# CITY OF ALBUQUERQUE

September 20, 2013

**Re: 5207 San Mateo NE, Temporary Detention Plan  
Engineer's Stamp Date-no stamp- (F17D095)**

TEMPORARY DETENTION

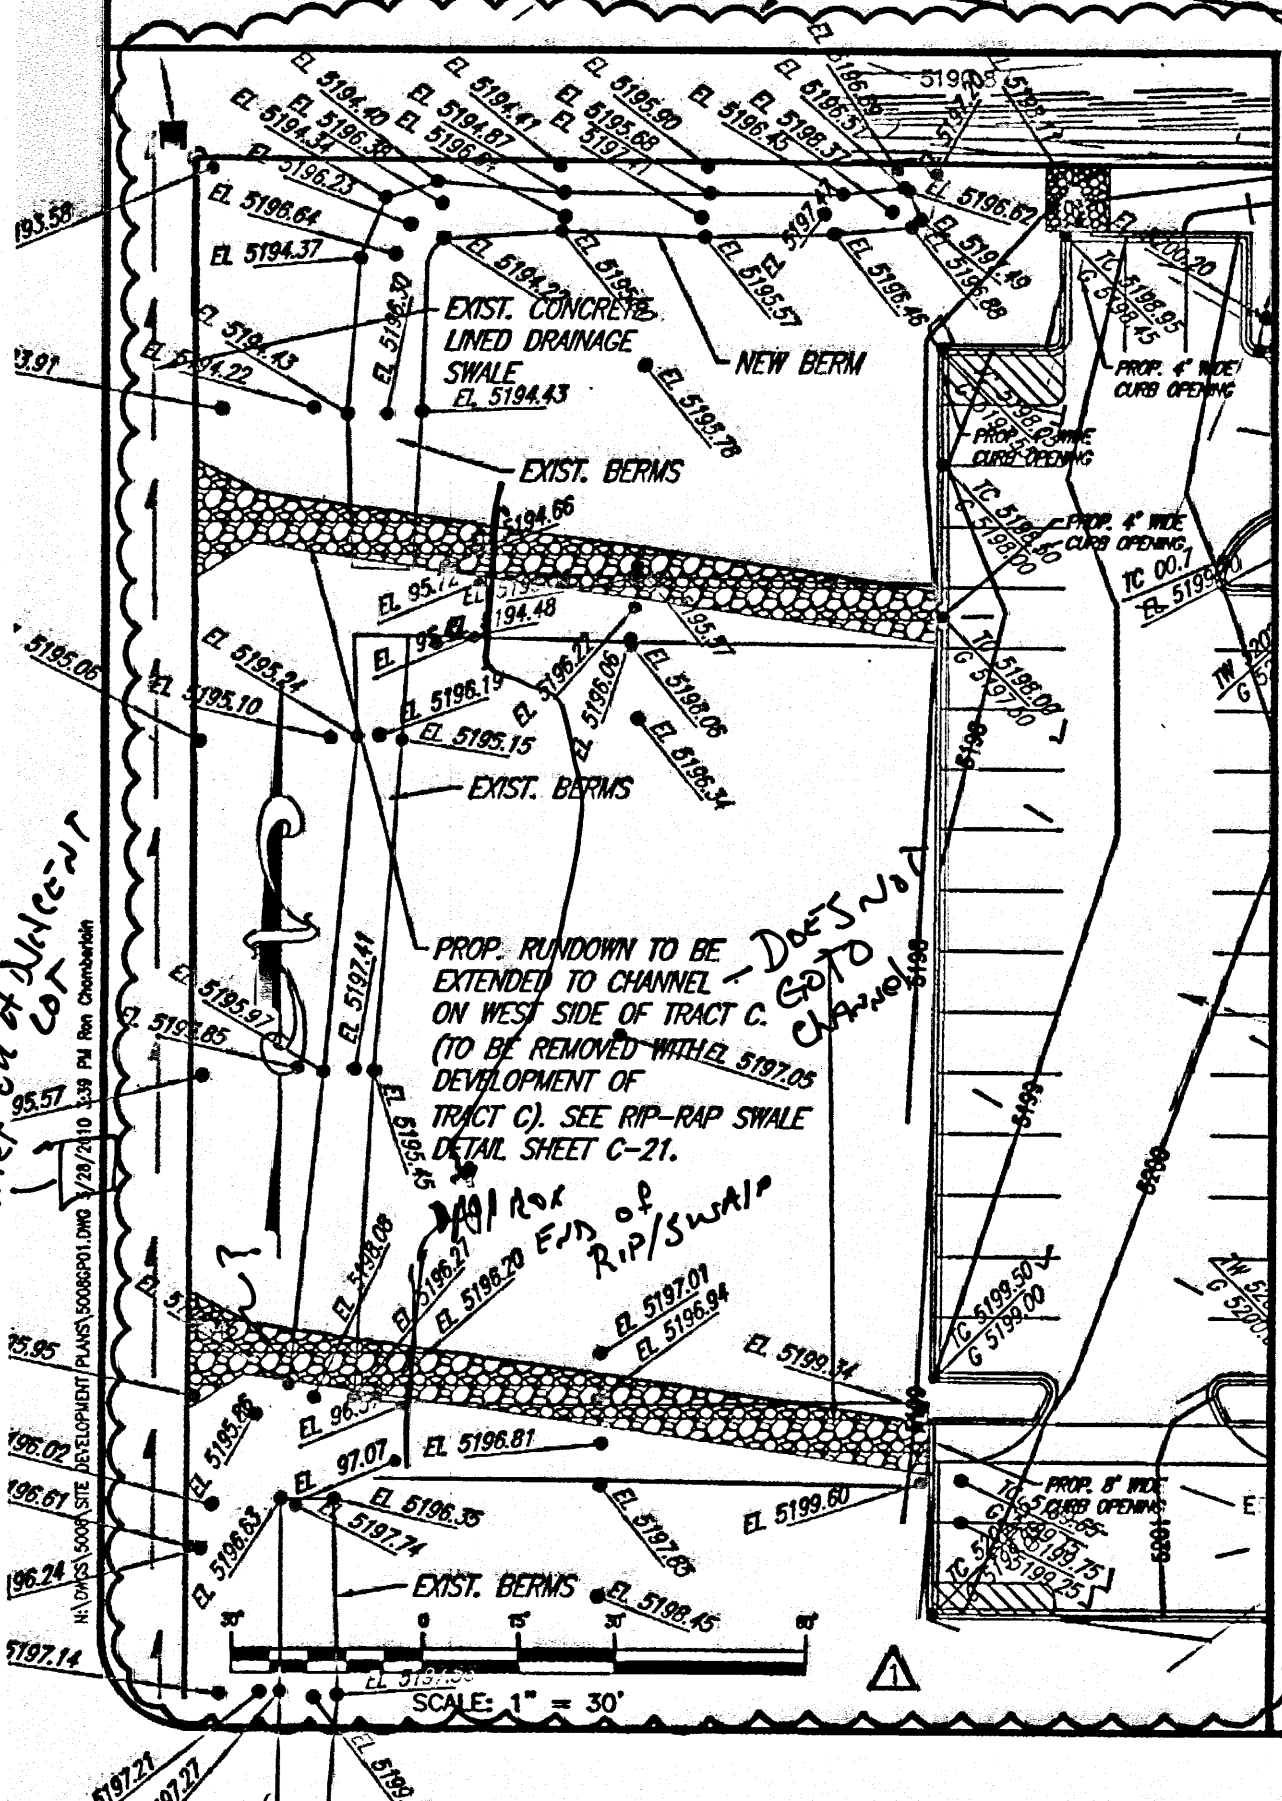
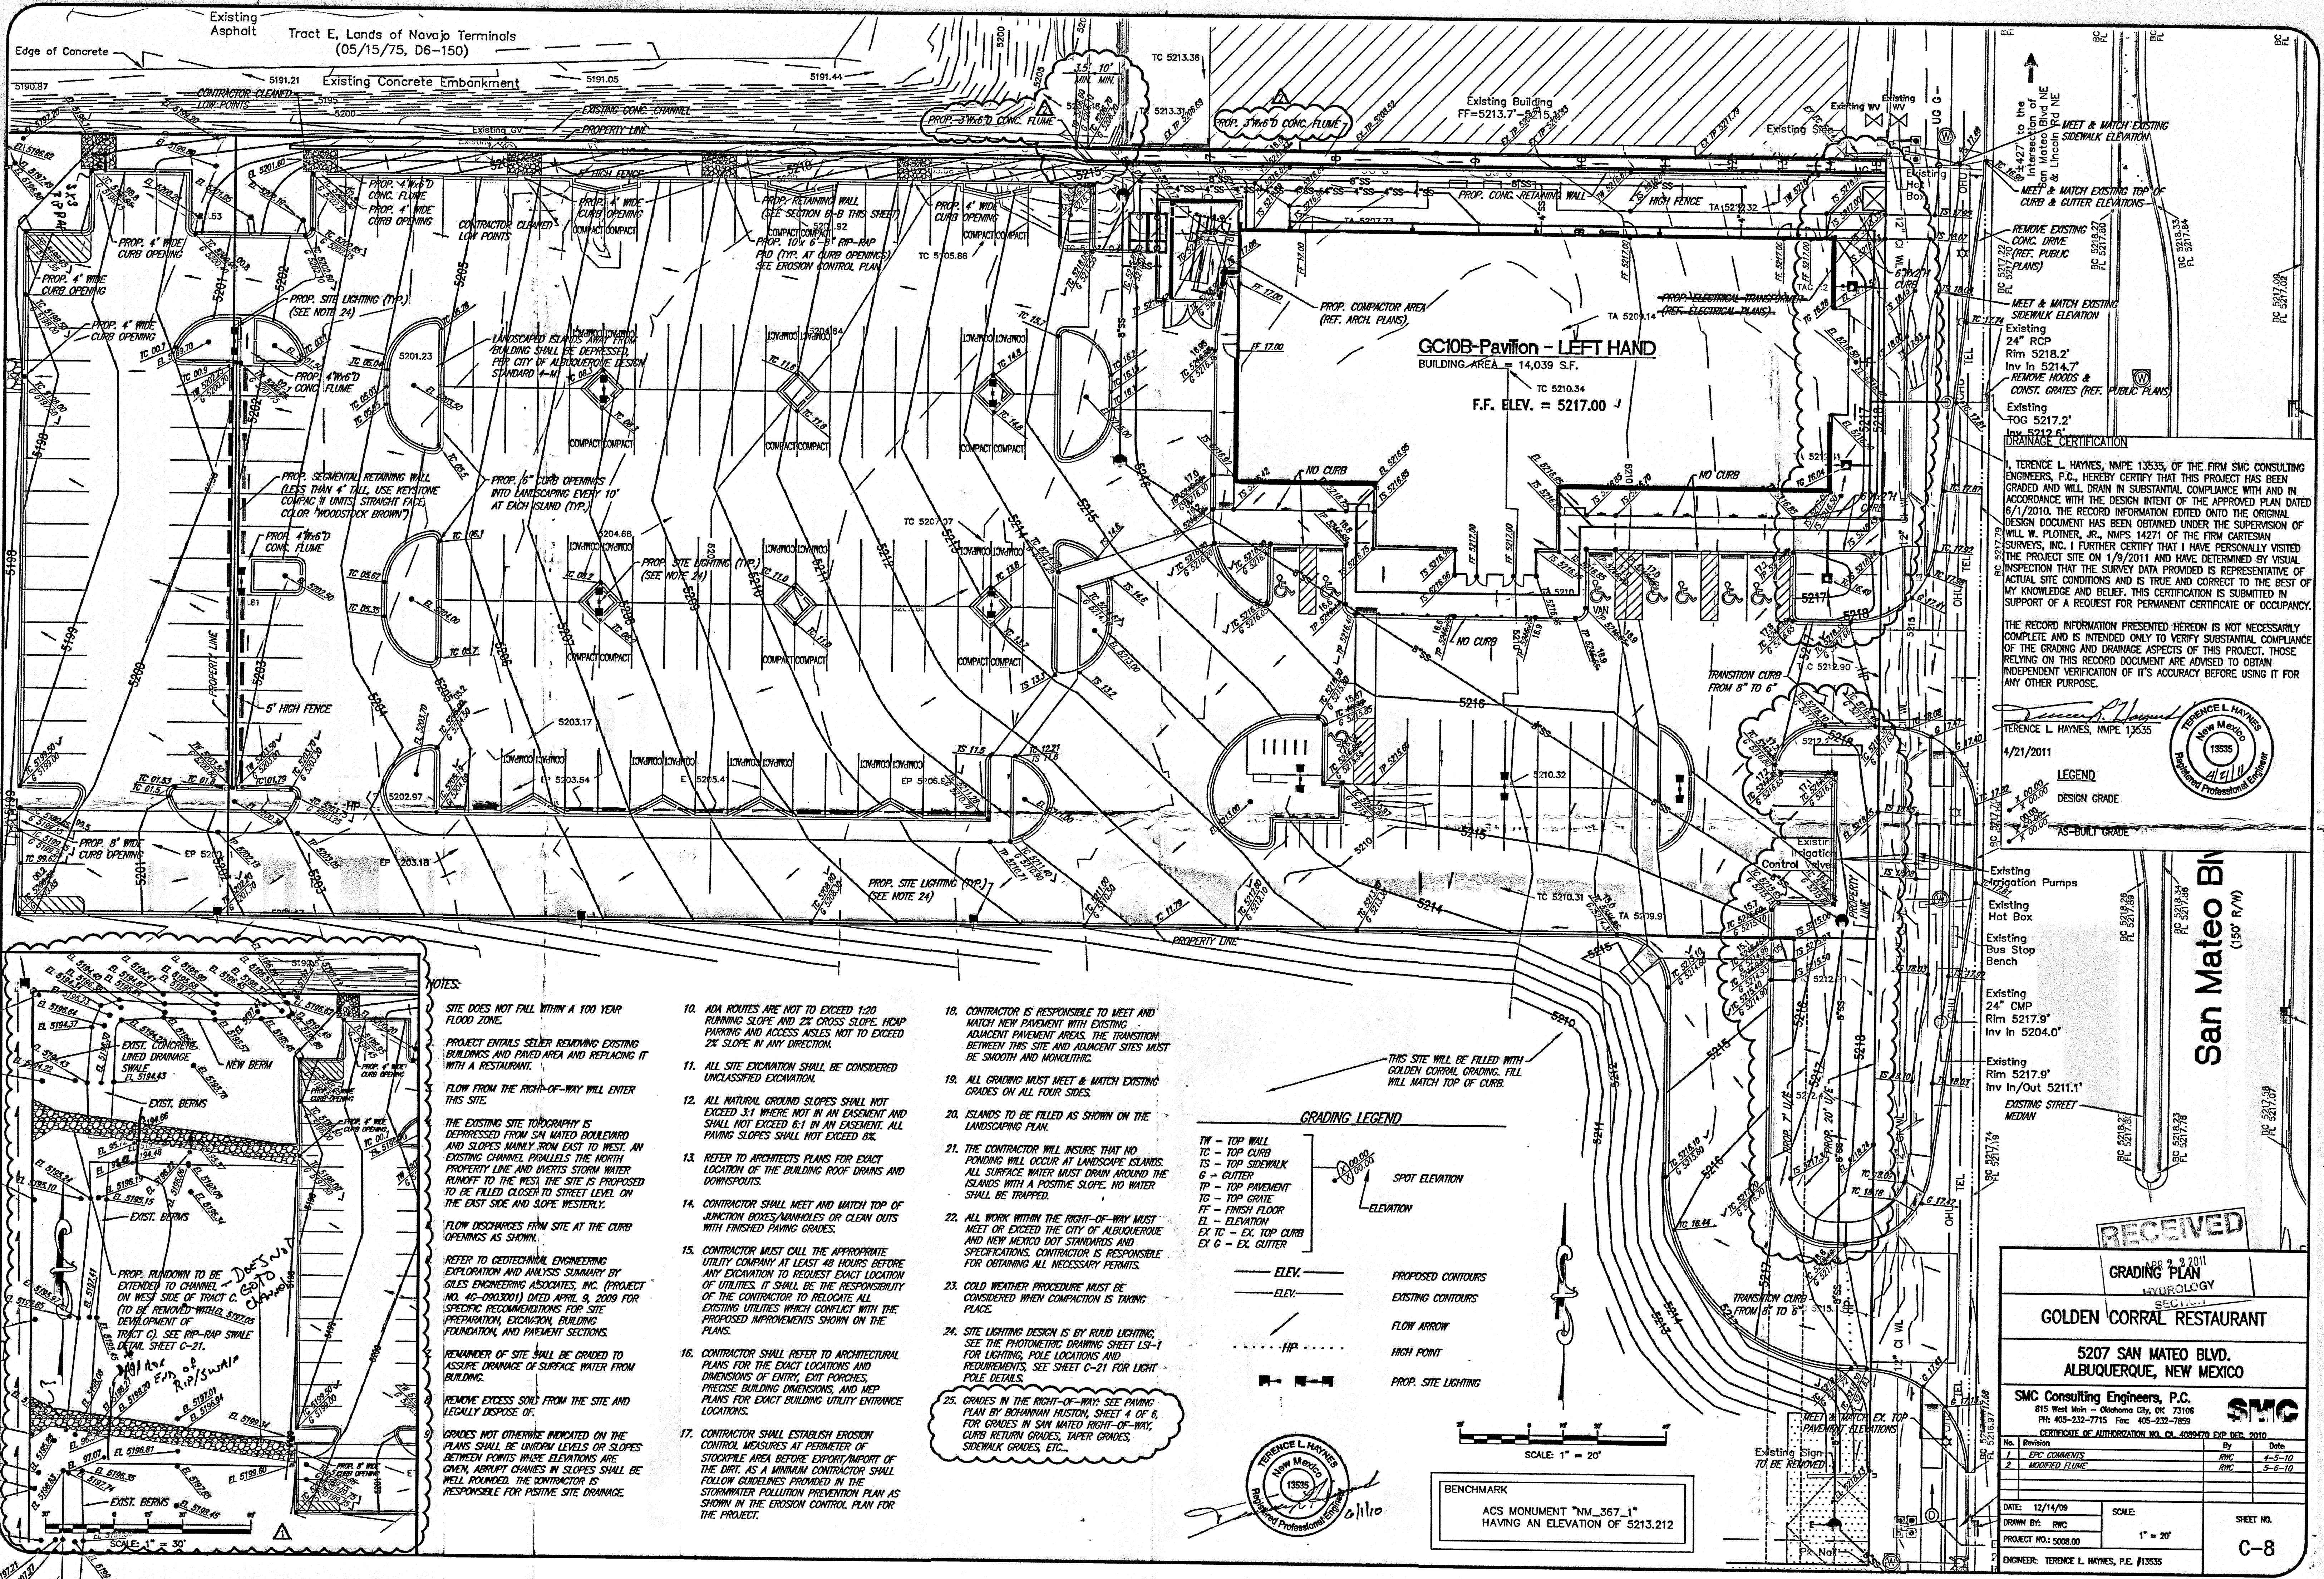
Hydrology provides the suggestion that the construction include a water-tight seal where flows from the drive aisle enter the existing channel on the ABF Freight site.
